**CITY OF PORTLAND, MAINE
DEVELOPMENT REVIEW APPLICATION
PLANNING DEPARTMENT PROCESSING FORM
DRC Copy**

RE: Application for – 35 Providence Street
(ID# 2003-0232, CBL#169-A-035)

Thank you for your application for your single family at 35 Providence Street. Upon review, planning has the following comments:

PLAN SHOWING A STANDARD BOUNDARY SURVEY MADE FOR MARK PLOURDE
 PORTLAND, MAINE

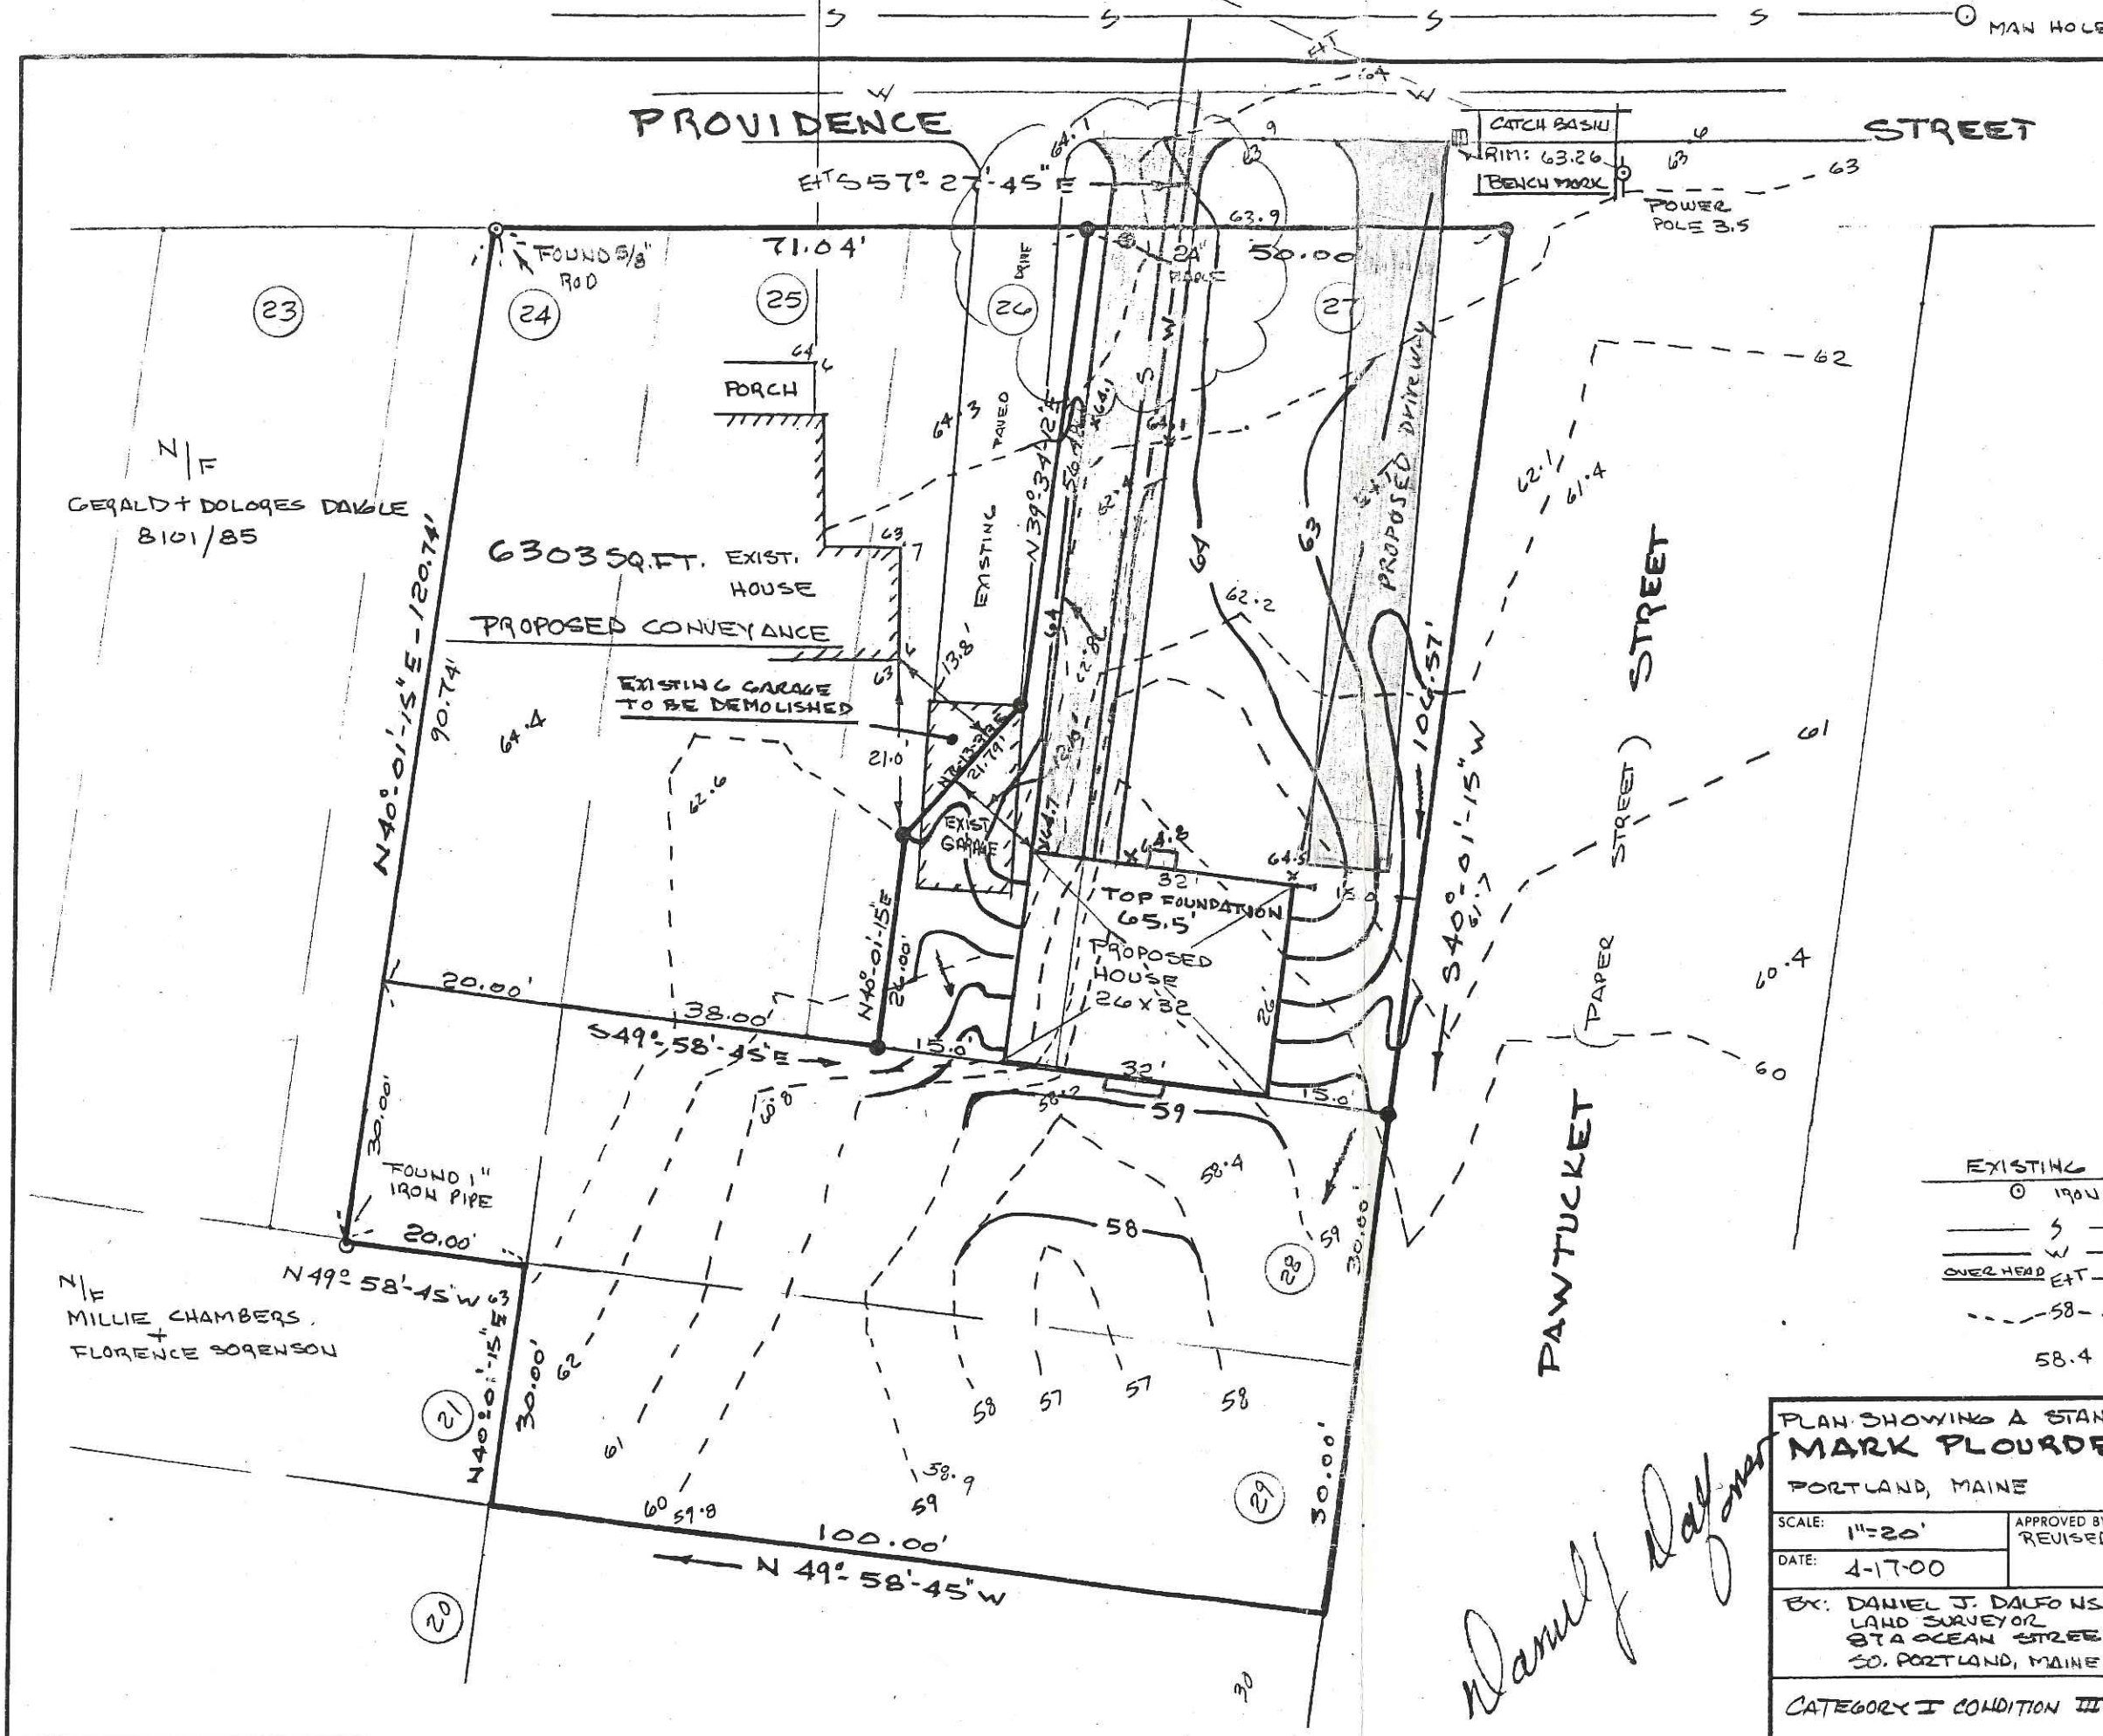
1. Please add a cleanout to the sanitary sewer lead. *Cleanout*
2. Please add two street trees to your site plan, as required for single family development. *Two*
3. The site plan appears to show two driveways/curb cuts. Is this correct? *One Curb Cut*
